**Consultation Response from KC,
Highways Development Management**

2026/92432 adj to, 46, The Fairway, Fixby, Huddersfield, HD2 2HU

Formation of a vehicular access and relocation of existing gates

Plan ref: PL-03_rev A; PL-04_rev A - Vehicular Access & Highway Alterations
Reference to refused planning application 2017/91286.

MA_PL-04_RevA

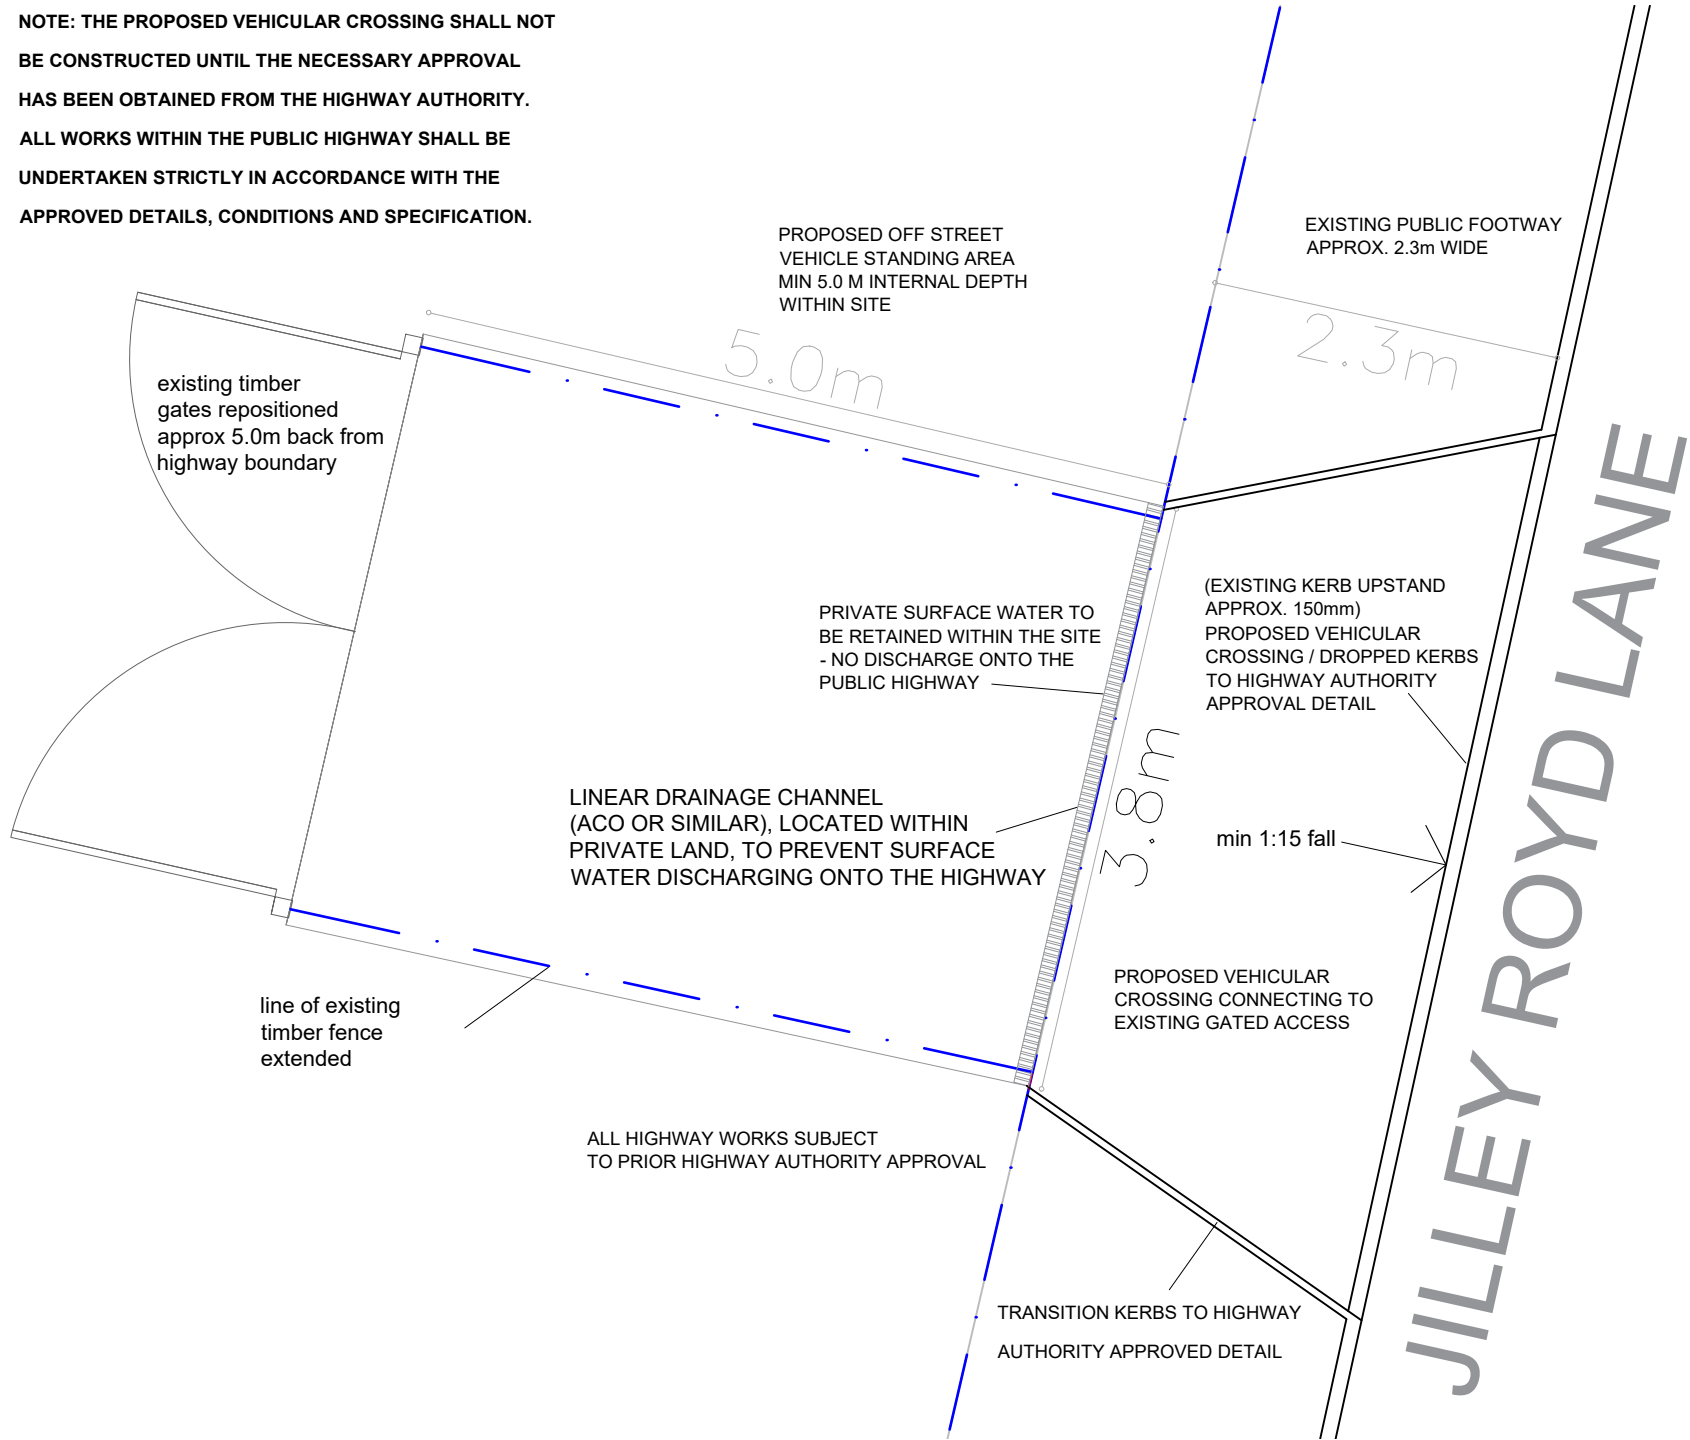
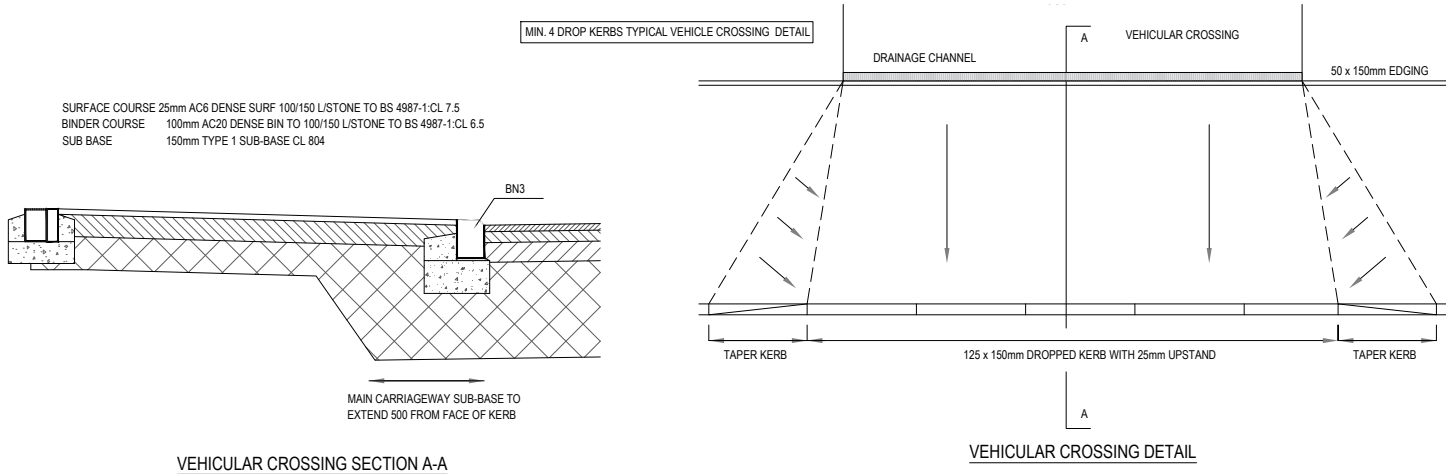
The existing access is gated with these gates opening inwards. To enable vehicular use a dropped crossing of the footway would be necessary to reflect the access width as illustrated on Drawing PL-04_rev A.

The access layout shown on Drawing PL-04_rev A would be adequate, and it is noted that HDM raised no objection under 2017/91286 and there was previous s184 licence granted by Highways in 2025 for the dropped crossing but revoked pending planning consent. A new dropped crossing application is likely to be necessary after grant of planning consent.

Visibility splays whilst not depicted are adequate. The site benefits from a 2.3m wide footway in advance which is marginally short of the standard 2.4m setback from the carriageway edge used for provision of junction exit sight lines and more than sufficient for a low flow route and occasional use where a 2.0m setback can be used. This would be subject to the frontage trees / planting being kept trim including any tree canopy overhang so not to restrict visibility within the sight line envelope at a height not exceeding 1.0m above the carriageway channel line.

The setback of the gates would create a recess of 5.0m depth which is typical of more modern low use fields and maintenance arrangements, such as for sub-station to the north side. These allow vehicles to pull off the road to avoid obstructive on-street parking along a road and help minimise impacts on any driveways opposite as in this instance. The user would have to reverse in or out which is acceptable for a minor route, and there would not be need for turning space incursion.

No details are given for the intended surface materials for the pull off area. A low dig solution, grasscrete or similar would be preferred to other hard porous surfaces, such as concrete or tarmac to

protect any tree roots and would negate the need for the Aco drain or similar to capture surface water as well as preventing debris and dirt from tracking onto the highway. Gravel would not be acceptable.

- a) Access and parking layout: Before the development hereby authorised is brought into use the vehicular access shall be laid out and constructed as shown on submitted details with any entrance gates set back a minimum of 5.0m from the back edge of the footway and hung so as to open inwards only.

- b) Surfacing: Development shall not be brought into use the area until surface materials details for the area in advance of the gate position have been submitted to and agreed in writing by the Local Planning Authority. The surfacing shall be fully implemented, and the development thereafter operated in accordance with the approved timescales.
